M54 to M6 Link Road

TR010054

**8.8 P(A) Statement of Common Ground with
Environment Agency**

Version	Date	Status of Version
7 (P09)	7 April 2021	Issue to the ExA at Deadline 8

Plot Date: 25 March 2021 15:53:50  
File Name: \\ukids2pfs001\ukids2pfs001\1\1\1\ENVIRONMENT\Practice Areas\GIS\Projects\M54\M6 Link\Workspace\Stage 4 Figures\landscape\HE514465-ACM-ELS-M54\_SW\_R\_Z-DR-LS-001 - Figure 2.1 Env Masterplan P17.mxd

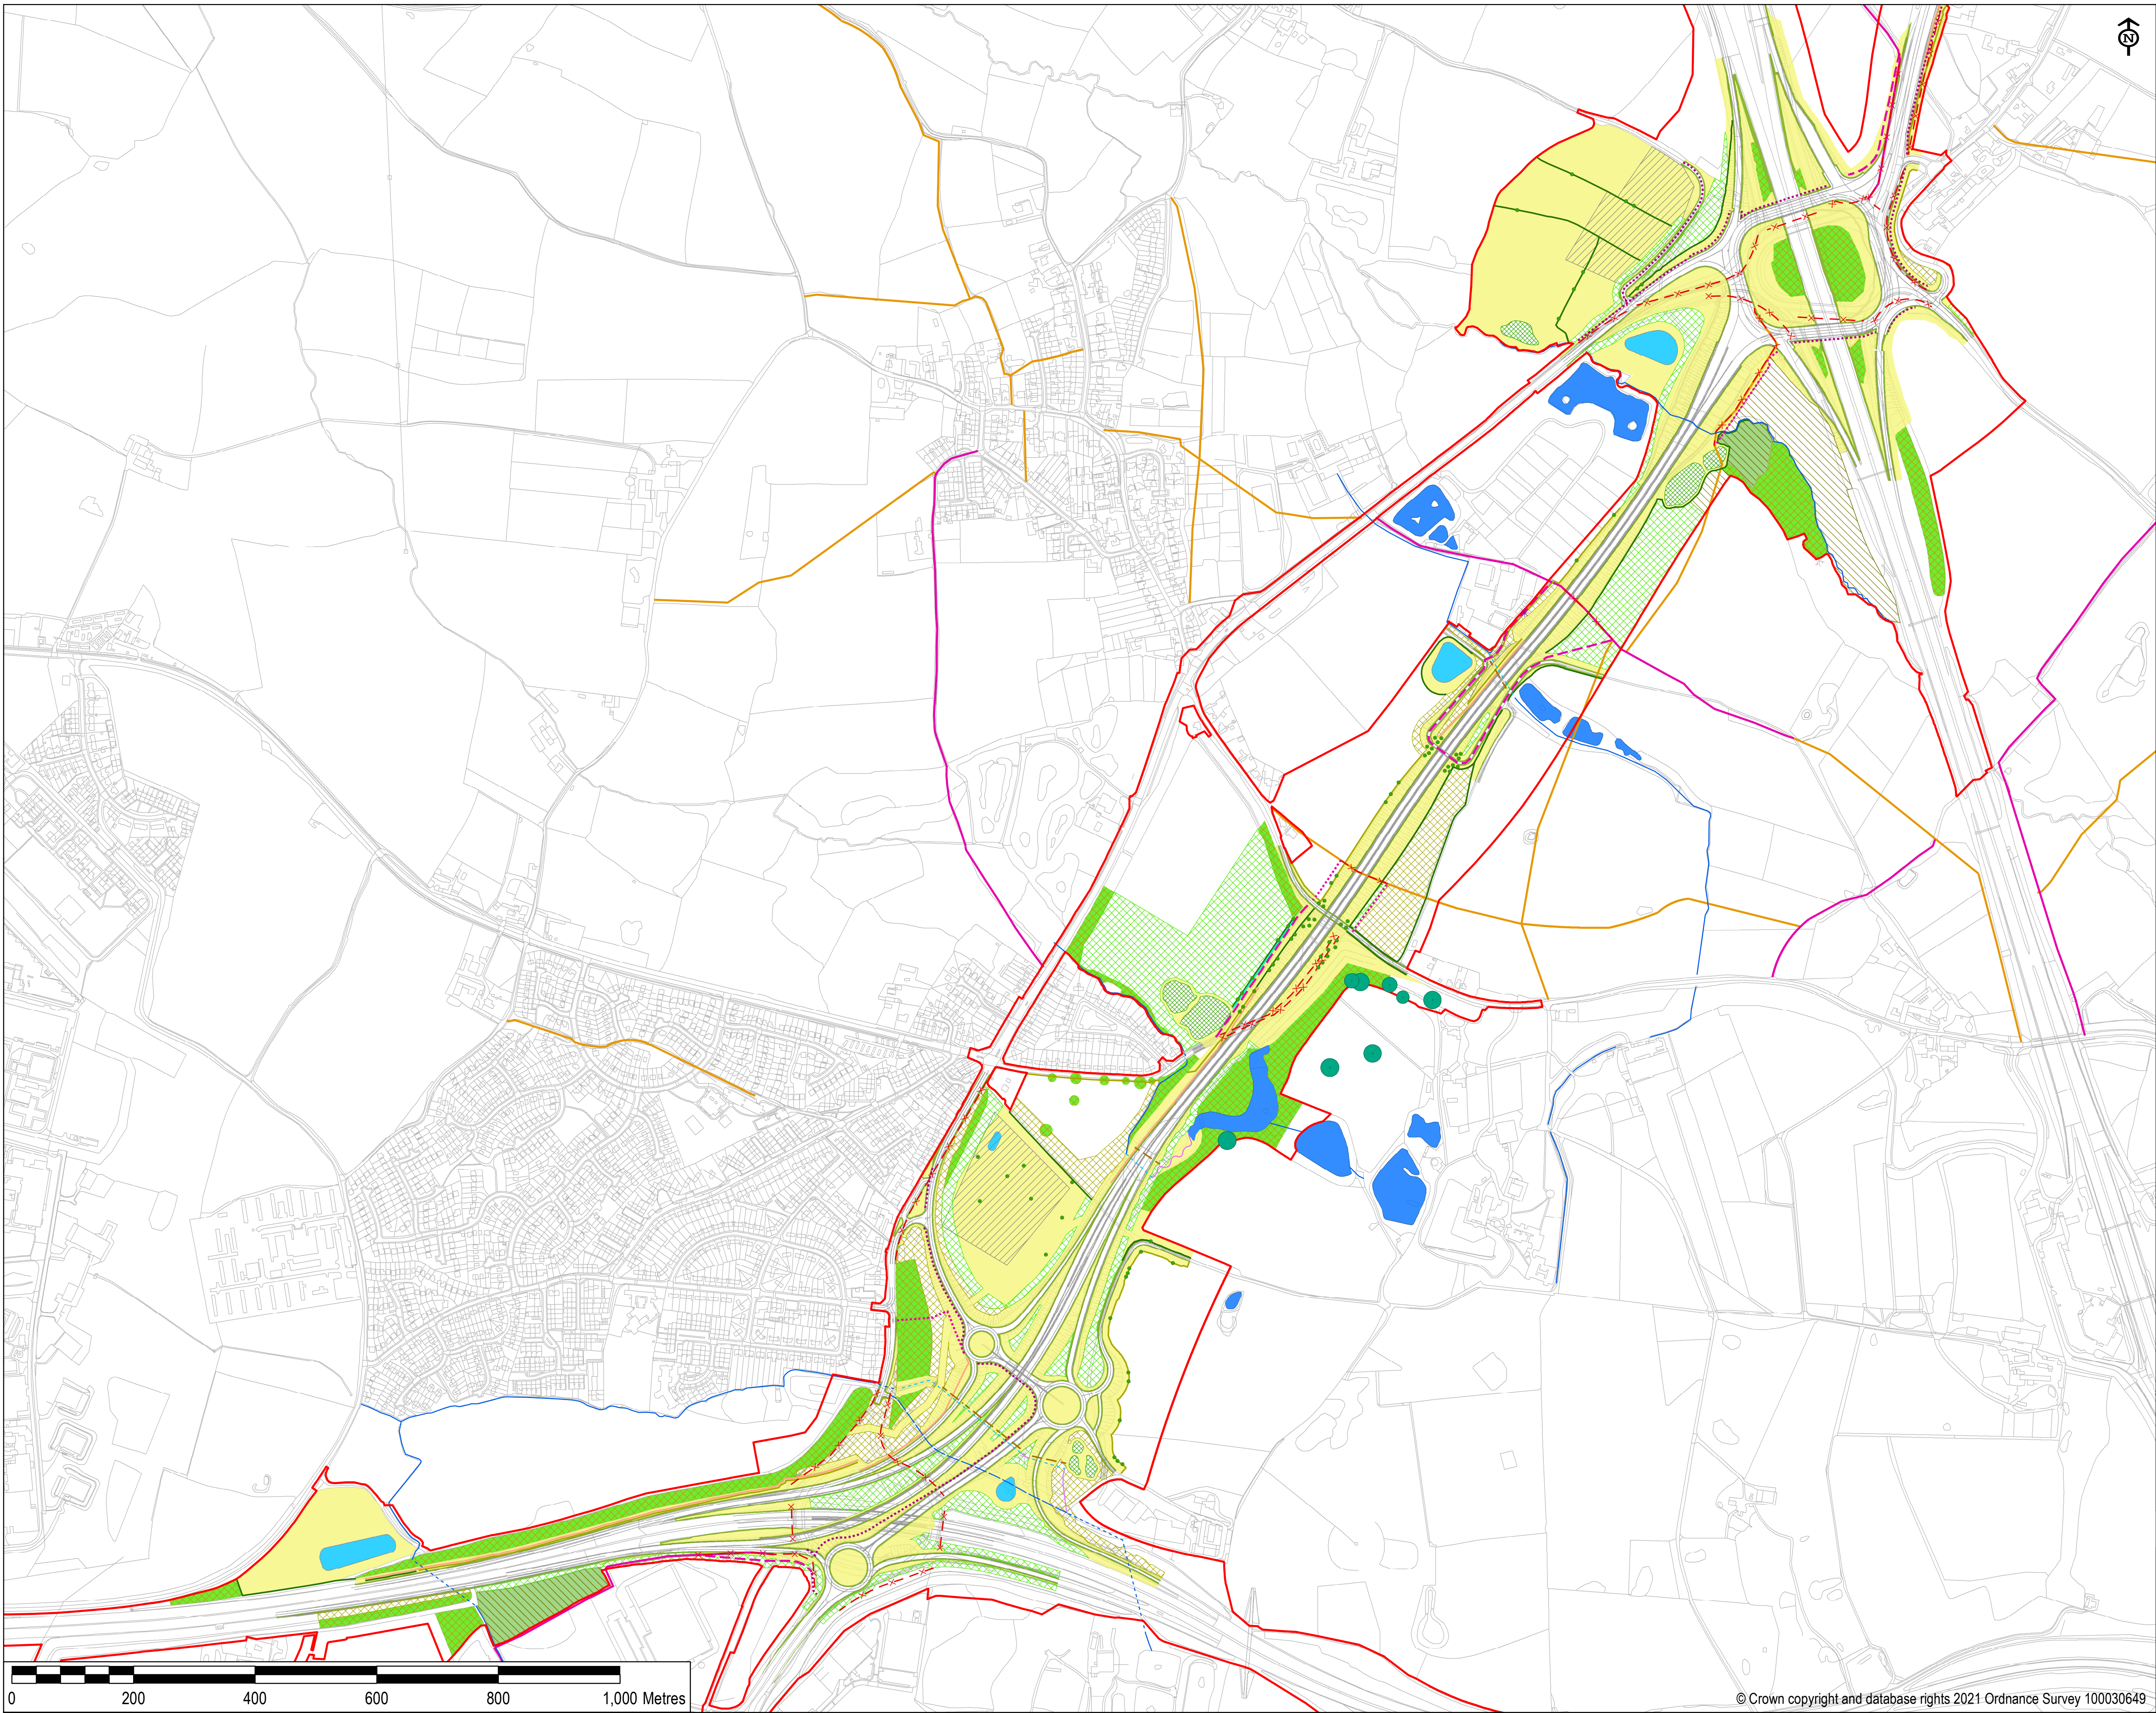
ES Chapter	Paragraph Reference	Sub-section	Environment Agency Comment	Highways England Response	Status	Agreement likely?	
						APP? ¹	IP?
				<p>13.2 Drainage Strategy [APP-201/6.3], Figure 2.1 of the ES Draft Environmental Masterplan Overview [APP-057/6.2], and Outline Drainage Works [AS-072/2.11] (see Sheets 3-5). However, to support the interpretation of the environmental commitments made and to help illustrate what the proposals aspire to provide, Highways England has prepared an additional figure, Figure 1: Proposed Watercourse which is appended to this SoCG. Although the detailed design of new ditchcourses, channel diversions and realignments will be done during the detailed design stage, and will be site specific, (a figure will be produced and provided to support this ongoing discussion), to illustrate project aspiration in terms of ditchcourse and existing channel diversion/realignment design.</p> <p>Following the result of 2020 great crested newt (GCN) surveys these mitigation measures have been reviewed and amended as appropriate. The surveys confirmed the likely absence of GCN in those ponds which would be lost as a result of the Scheme. As no ponds known to support GCN would be lost the replacement of pond habitat is only required at an</p>
